Application for a non-material amendment following a grant of planning permission.

Change of use of land from permitted B8 storage use & erection of new detached office building (Use Class B1) with access via Hangleton Lane & associated car parking, cycle storage & refuse storage. This is a Departure from the Development Plan.

Reference number:	FG/183/17/PL
Date of decision	10/05/2018

We are seeking to move the building northwards by 1.0m and alter the fenestration due to internal layout changes

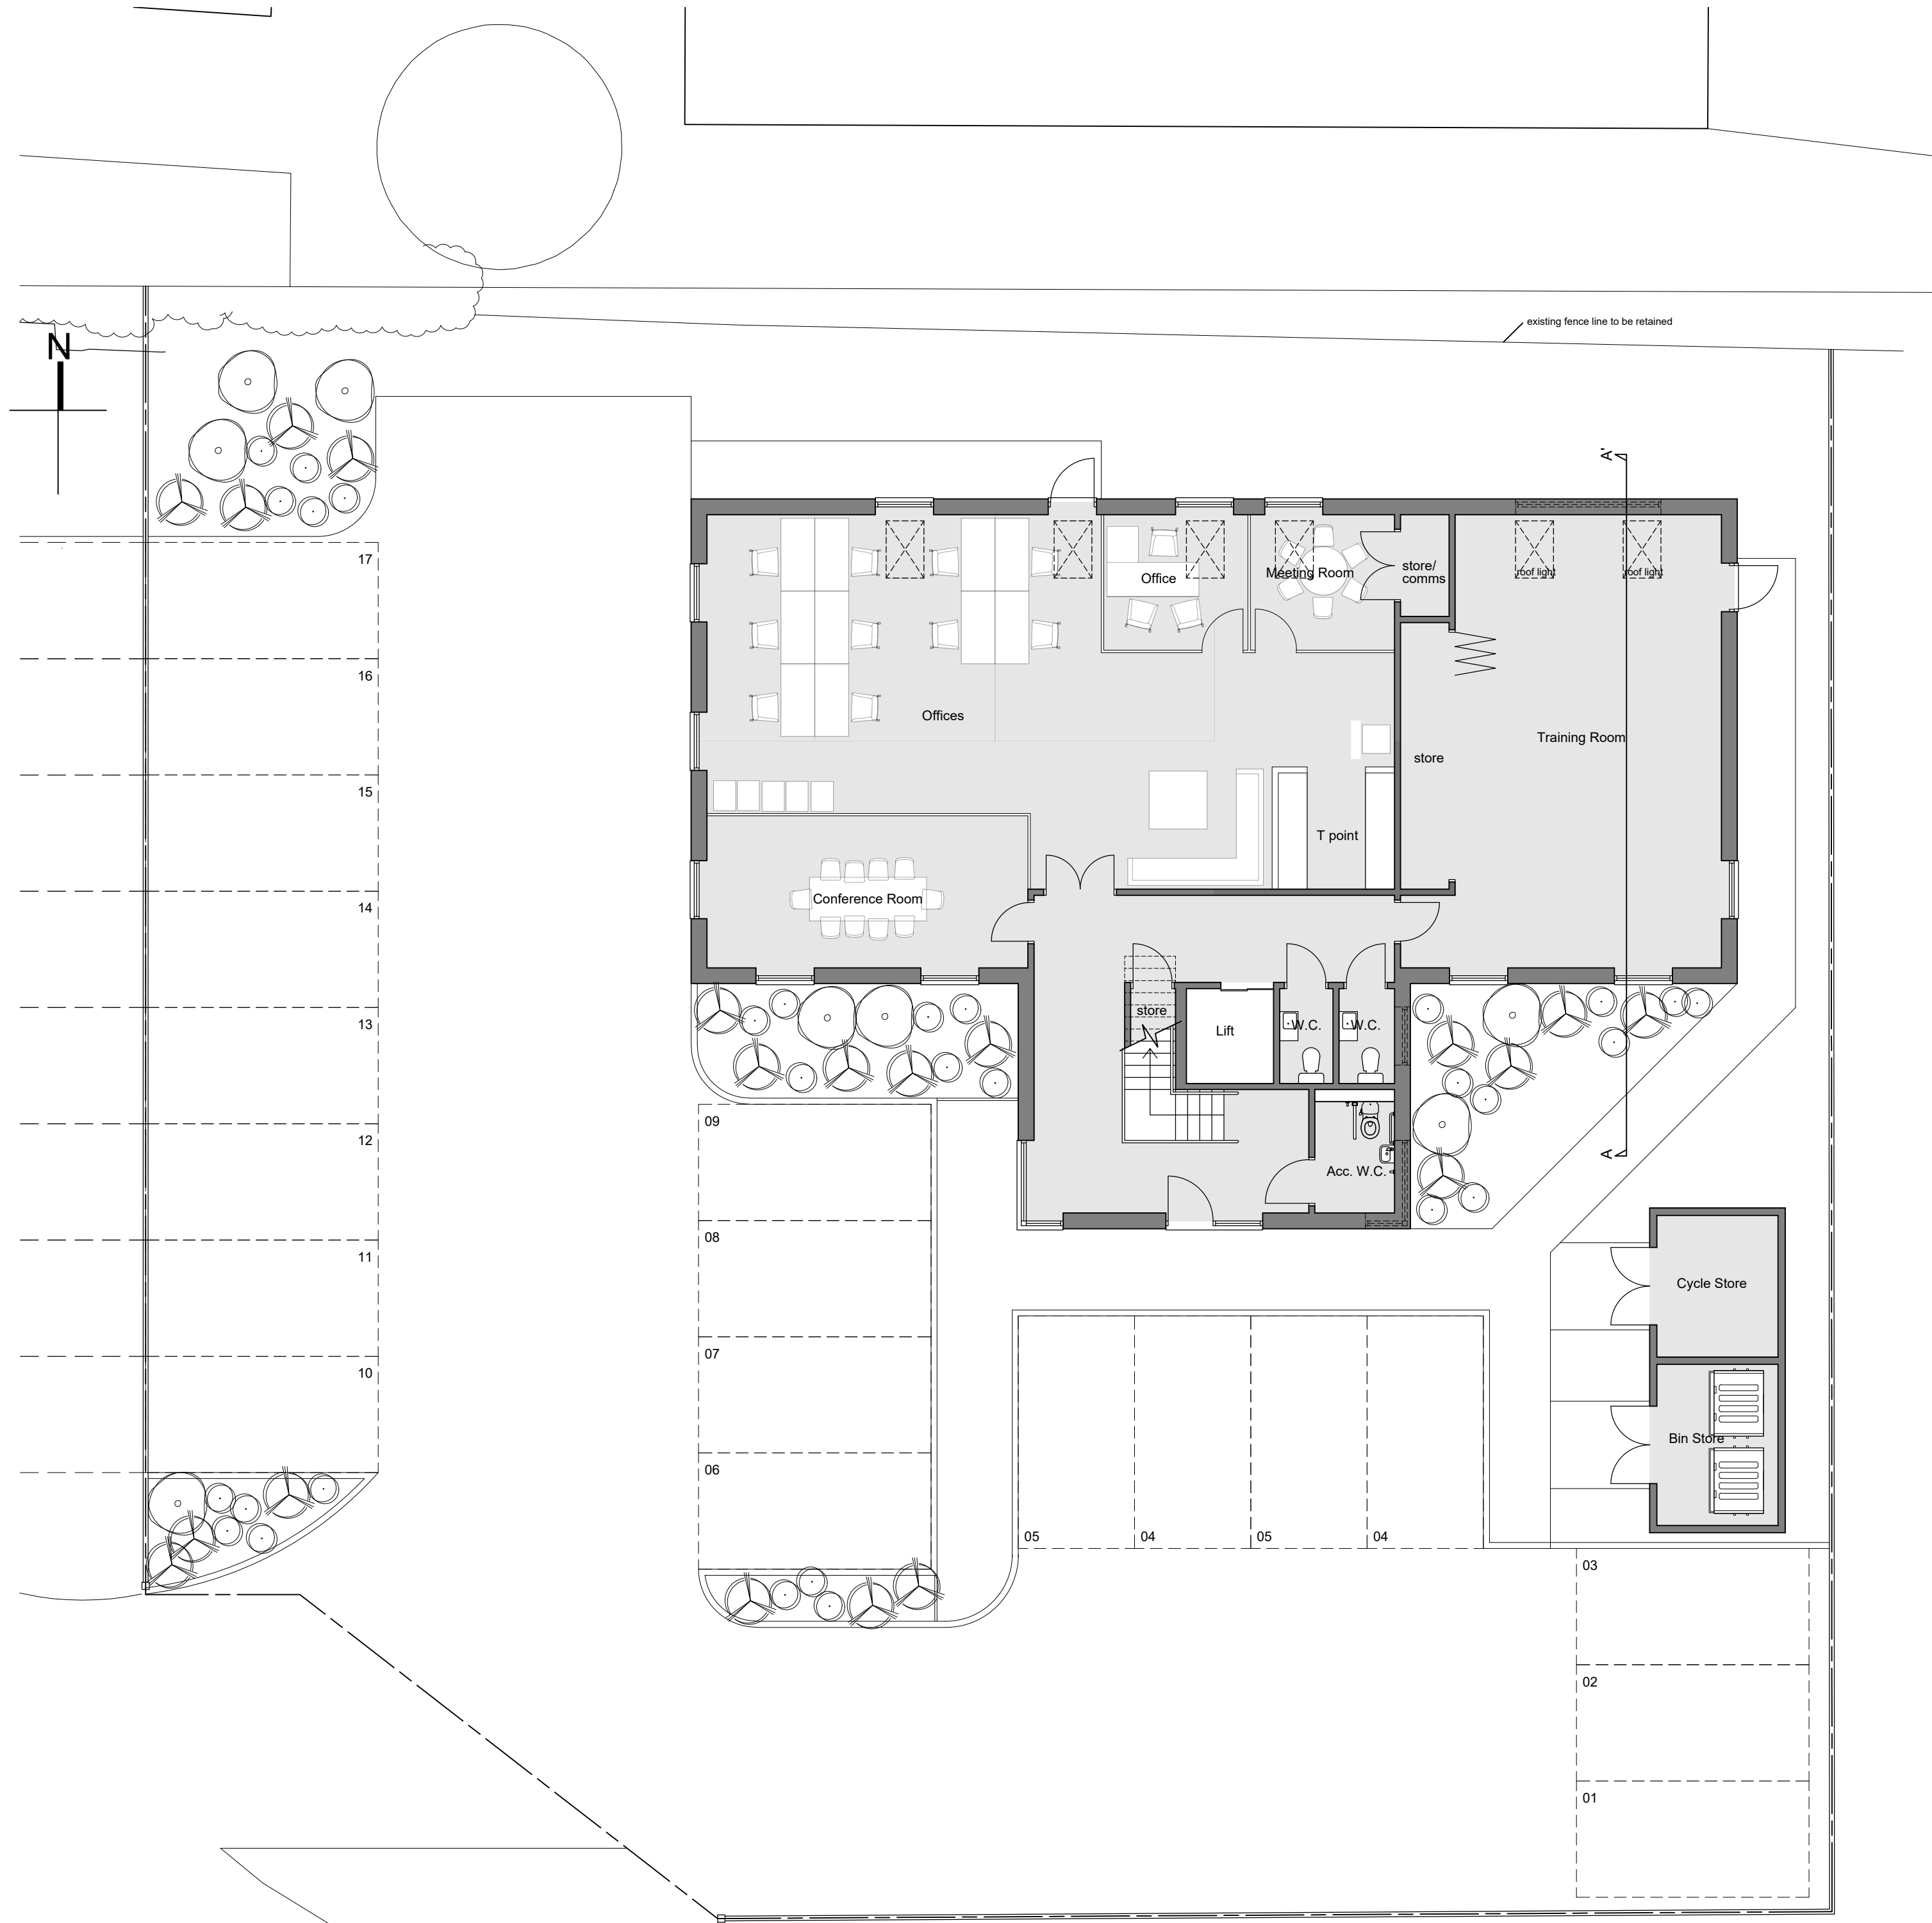
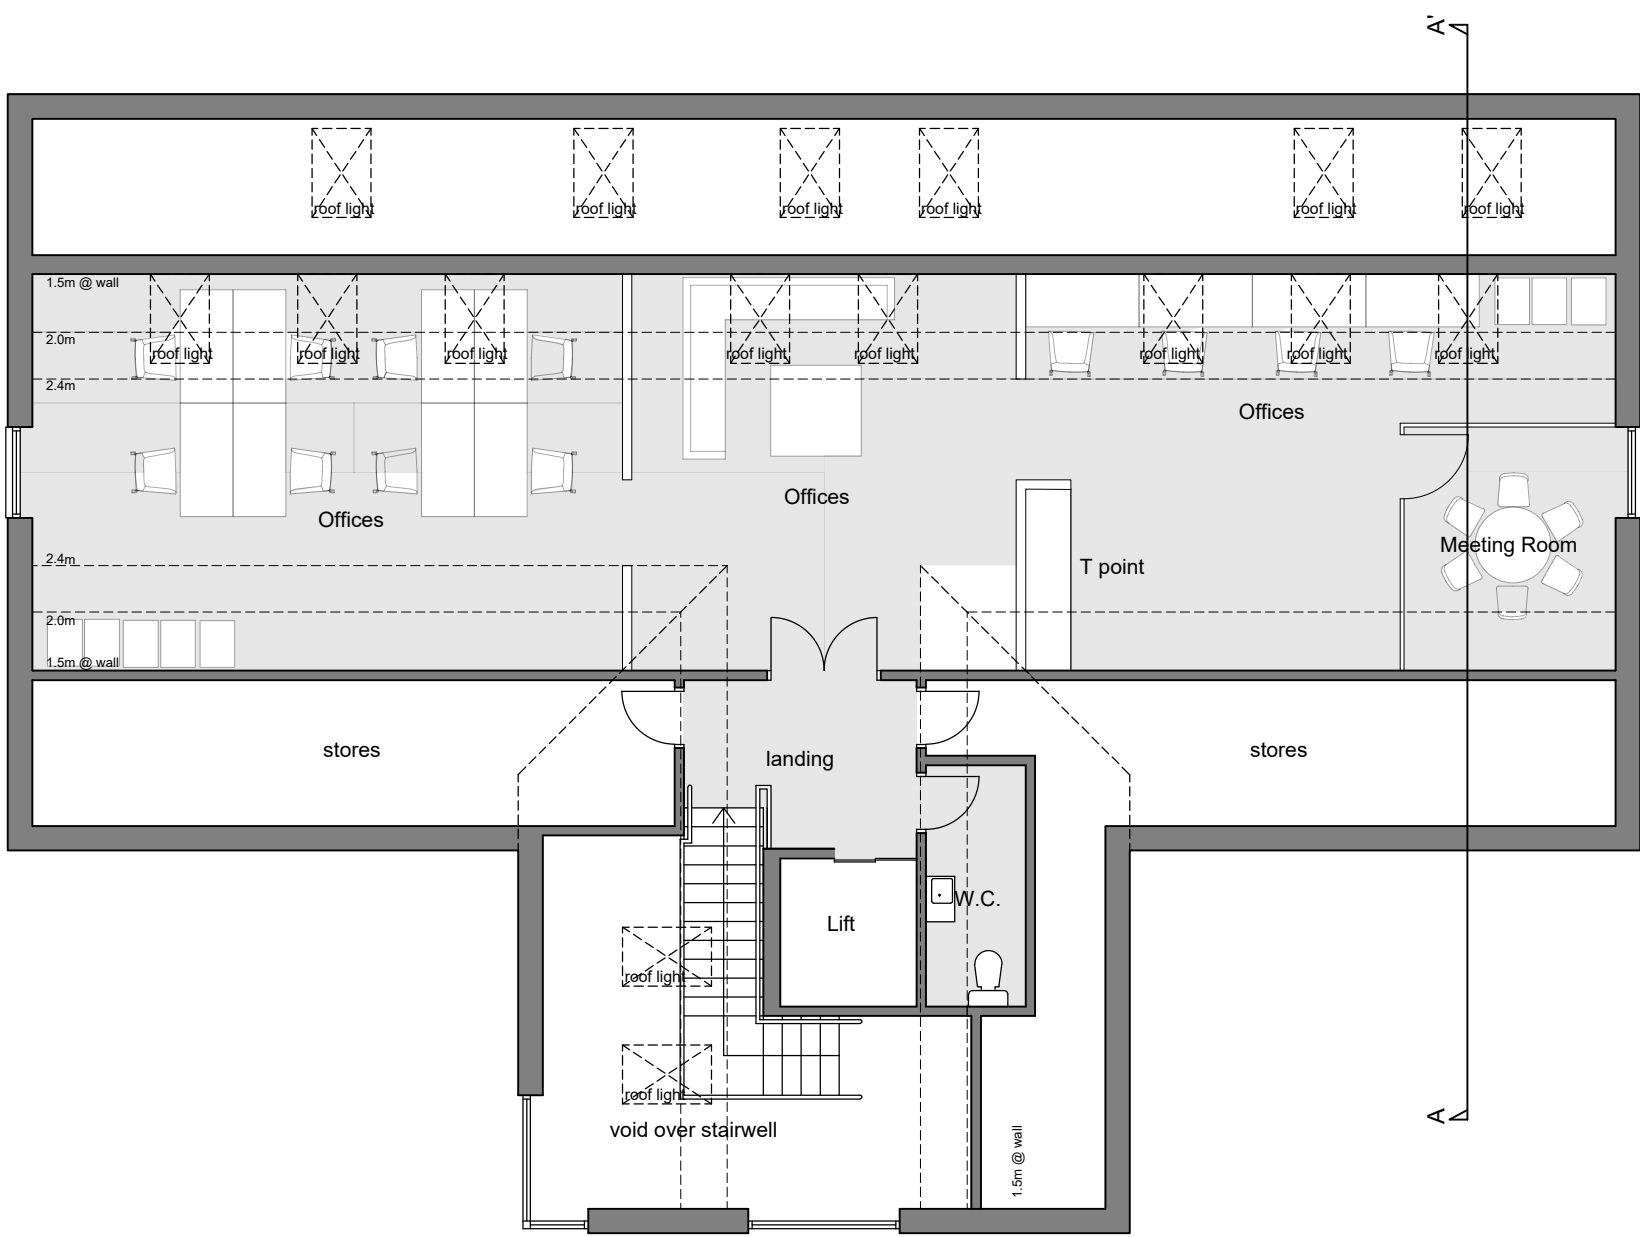
the applicant wanted to make a number of internal changes to improve the flexibility of the internal spaces, therefore requiring a re-design of the vertical circulation and internal layouts, which required a re-design of the external fenestration
